From: Hannah Kersley
Sent: 06 January 2025 09:19
To: Planning.Responses
Subject: FW: BR/232/24/HH - 11 Chichester Road
Attachments: CHICHESTER ROAD PL 304 A - PROPOSED.pdf; BR-232-24-HH request.docx

From: Oleksandr Sapozhnyk [REDACTED]
Sent: 04 January 2025 20:06
To: Hannah Kersley <Hannah.Kersley@arun.gov.uk>
Subject: Re: BR/232/24/HH - 11 Chichester Road

PROPOSED SECOND FLOOR PLAN  
SC. 1:100 @ A3

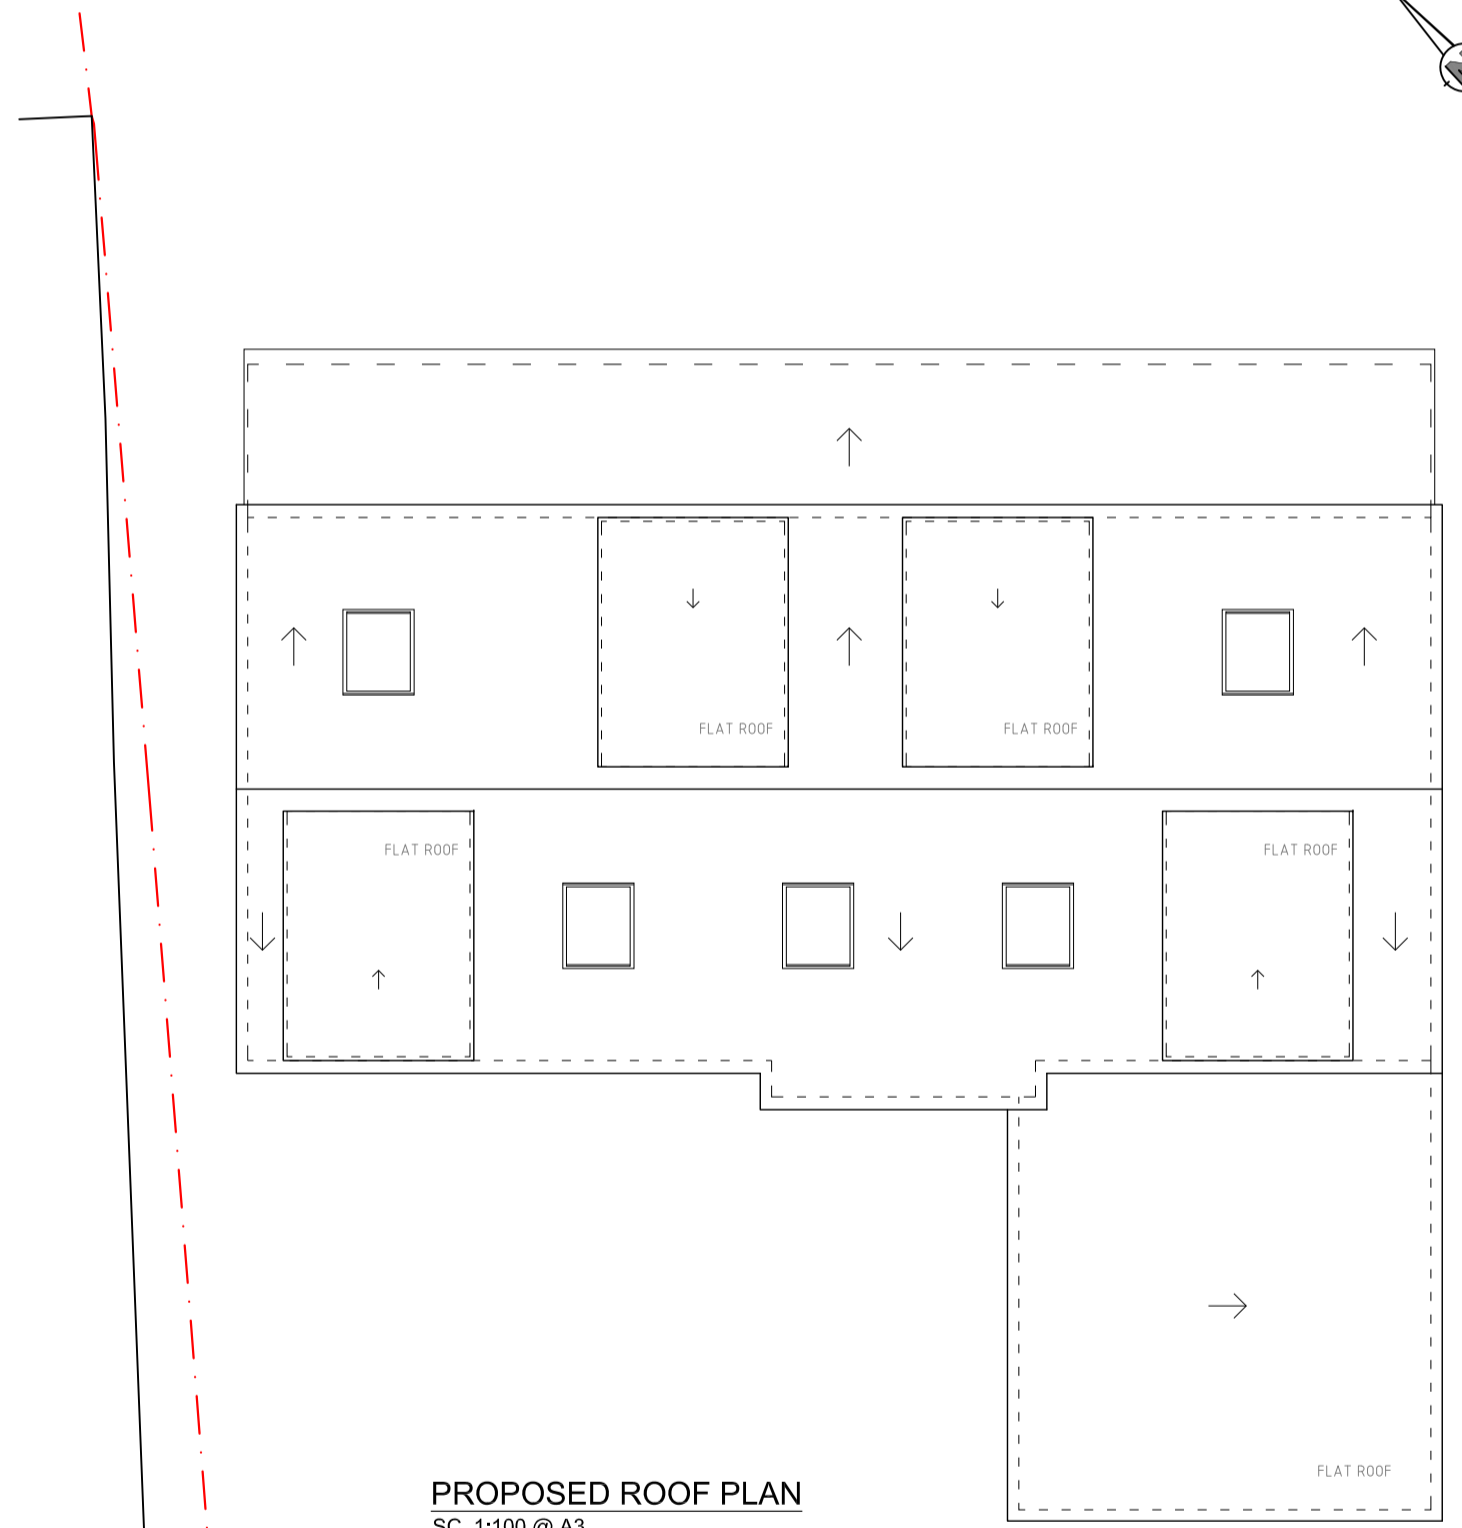
I have assessed the proposal and discussed with my manager. I can advise that we are happy to accept the dormers and rooflights to the front elevation. However, we do have significant concern with the dormers to the rear, and the overbearing impact this would have on neighbouring properties nearby. Whilst we do also appreciate the windows on the dormers have been obscure glazed, there will be a perception of overlooking, which is not acceptable. As such, as the proposal stands, we cannot support the application, and would need to recommend it for refusal on the grounds of harm to neighbouring amenity.

However, were you to be happy to remove the rear dormers, and replace these with rooflights, I can advise that we would be more amenable to recommending approval. Should a rear dormer be absolutely necessary, we would need to insist that only one be proposed, and this be minor in scale and with no window – preferably with a gable or hipped roof if possible to reduce its prominence on the main roof. This must also not be located towards the north-western edge of the roof, as so to preserve the outlook of residents of Saxby Lodge.

Following your advice we have omitted the rear dormers.

Please find attached the revised PL 304 A drawing.
